784-B028030

23rd February 2022

Response to comments received from Carol Reynolds, Senior Environmental Health Officer at Arun District Council (ADC) regarding the submitted Noise Assessment by Tetra Tech [ref 784-B028030 dated 28th April 2021] for planning application reference LU/206/21/RES.

Figure 4.2 Proposed Night-time $L_{Aeq,8hr}$ Noise Contour Plot (Grid Height: 4.0m)

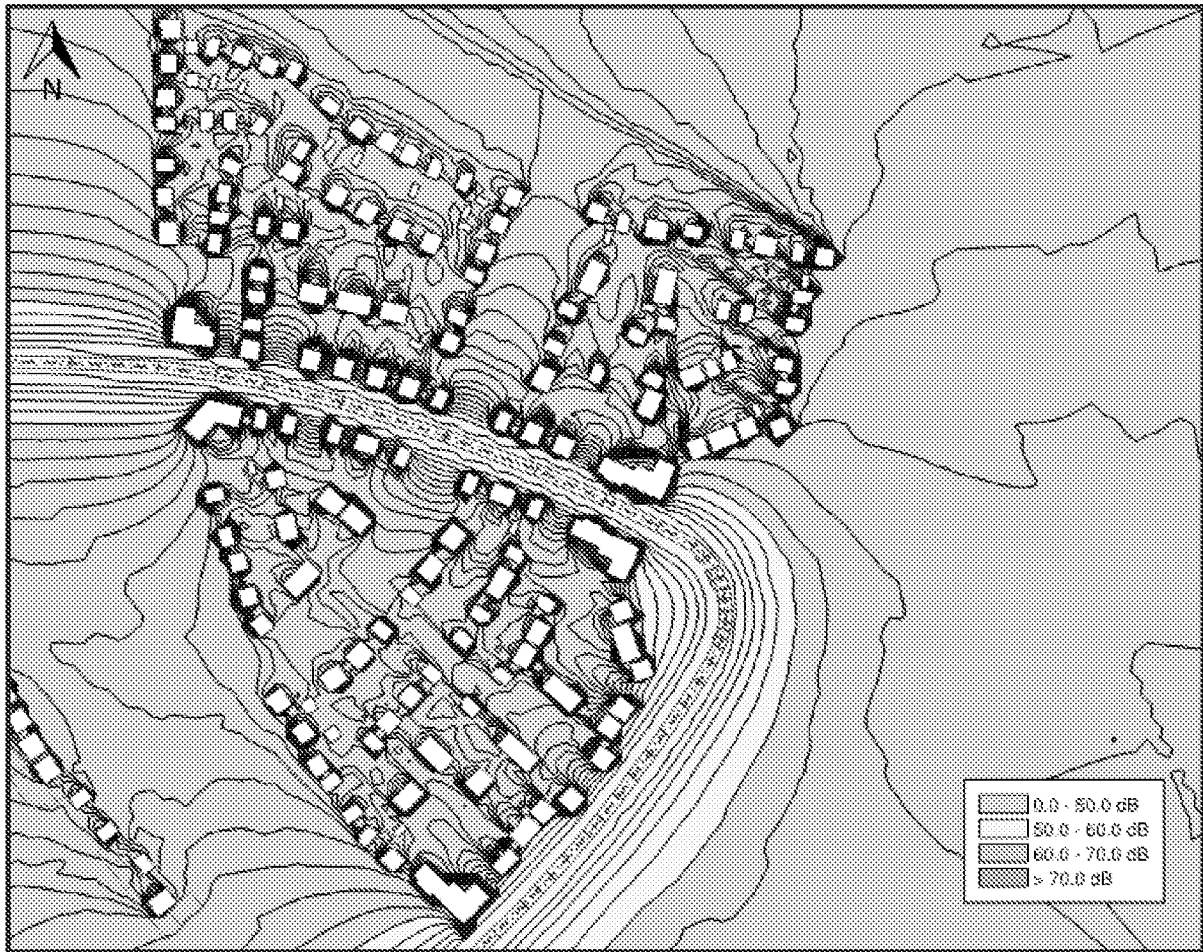
I would be obliged if you would explain why a correction of -3.7dB has been made to the night-time noise levels.

As the traffic flow data for the link road is provided in 18hr format, a correction has been applied to convert the predicted L_{A10,18hr} traffic flow data to L_{Aeq,8hr} noise levels for the purposes of the night-time assessment. The correction is referenced within 'converting the UK traffic noise index L_{A10,18hr} to EU noise indices for noise mapping' by TRL Limited.

Figure 5.1 Glazing and Ventilation Strategy

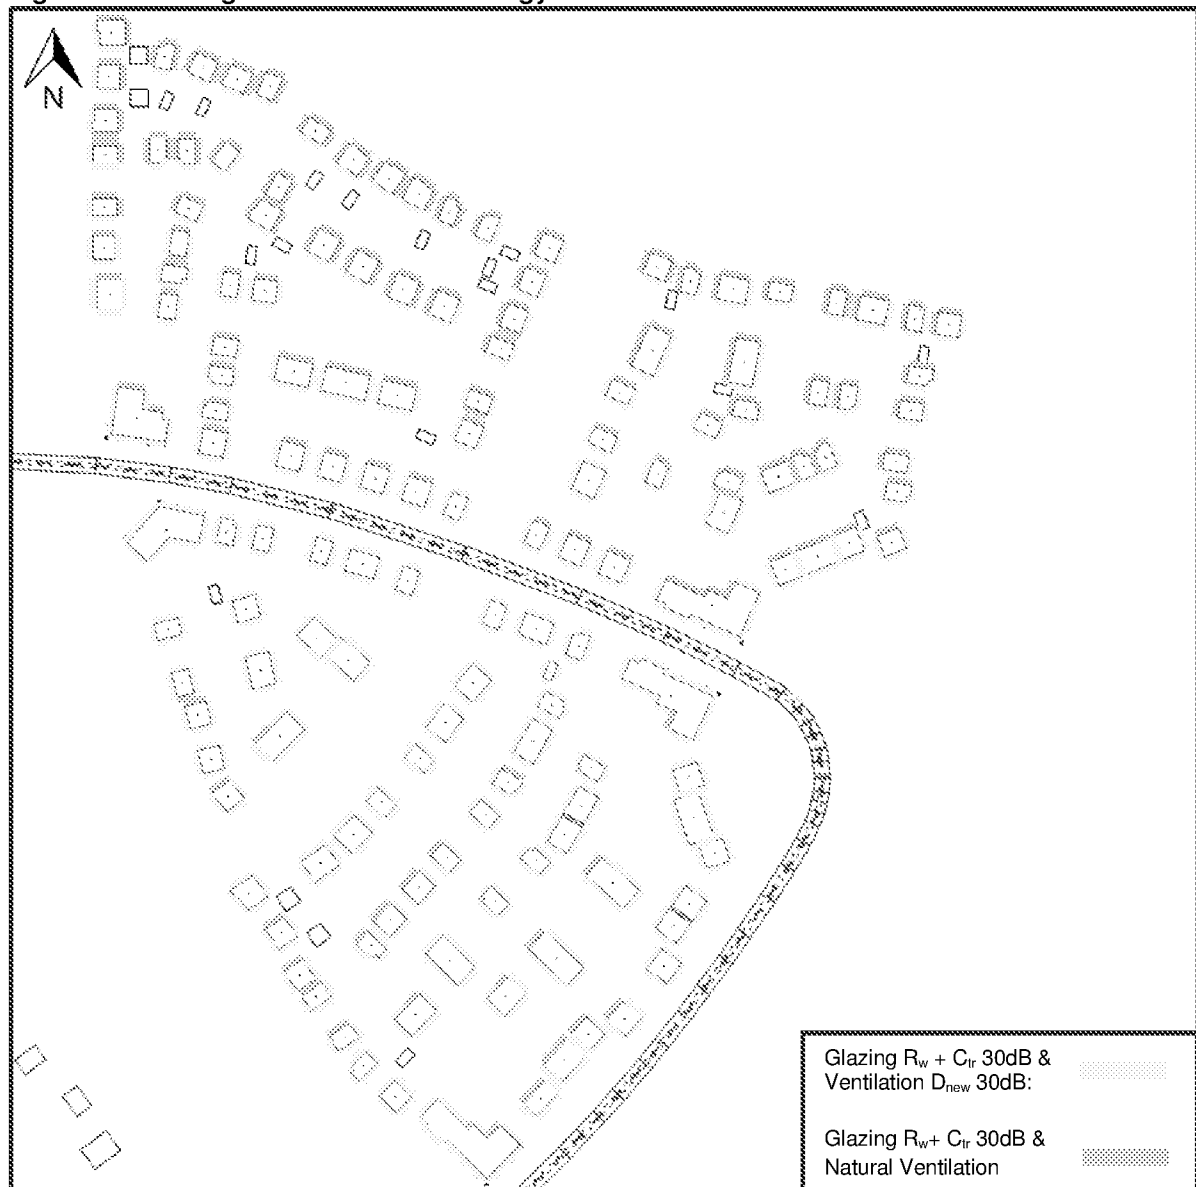
In this case, mechanical means of acoustically treated artificial ventilation should be provided to all adversely effected houses and flats, so that future occupants will have the option of controlling thermal comfort with the windows closed. Such a system should be based on based on MEV3 or 4 as detailed in the Building Regulations, Approved Document F. Whereas the report mentions that mechanical ventilation may be required, this is excluded from Fig 5, Glazing and Ventilation Strategy which only details proposed glazing and passive ventilation.

Within Section 5.1 of the noise assessment, a ventilation specification of D_{new} 30dB is outlined within Figure 5.1 for a number of facades across the site. In order to provide more detailed analysis of the type of ventilation required and assess thermal comfort, the Acoustic, Ventilation and Overheating Guide (AVOG) 2020 has been consulted. This provides guidance for acoustic assessments for residential developments, providing clarity on the relationship between acoustics, overheating and appropriate ventilation requirements. With regards to overheating, AVOG states that as overheating is a temporary condition, during this period "occupants may accept a trade-off between acoustic and thermal conditions, given that they have some control over their environment," and that occupants may "be more willing to accept higher short-term noise levels in order to achieve better thermal comfort."

As shown above, the majority of living room spaces and south-facing facades across the site fall within the Negligible to Low-risk category as defined within the AVOG and therefore as shown within Figure 1 the 'use of opening windows as primary means of mitigating overheating is not likely to result in adverse effect.' Additionally, although not required under the AVOG, acoustic trickle vents are to be installed on a number of living room facades as identified within the noise technical report and combined with the option to open windows, dwellings will be suitable for both thermal and acoustic comfort. Facades exposed to the link road fall just within the Medium Risk category in accordance with the AVOG, however given the predicted levels across the site and given a majority of facades are not south-facing, acoustic trickle vents are considered to be a suitable means of ventilation for these facades.

As shown above, nearly all bedroom spaces and south facing facades across the site fall within the Negligible to Low risk categories in accordance with the AVOG and therefore as detailed within Figure 1, the ‘use of opening windows as primary means of mitigating overheating is not likely to result in adverse effect.’ Additionally, although not required under the AVOG, acoustic trickle vents are to be installed on a number of living room facades as identified within the noise technical report and combined with the option to open windows, dwellings will be suitable for both thermal and acoustic comfort. Facades exposed to the link road fall just within the Medium Risk category in accordance with the AVOG, however given the predicted levels across the site and given a majority of facades are not south-facing, acoustic trickle vents are considered to be a suitable means of ventilation for these facades.

An example of acoustic trickle vents which achieve the minimum specification of D_{new} 30dB are Titen’s SF Xtra Sound Attenuator Vent where details are presented in Appendix A.
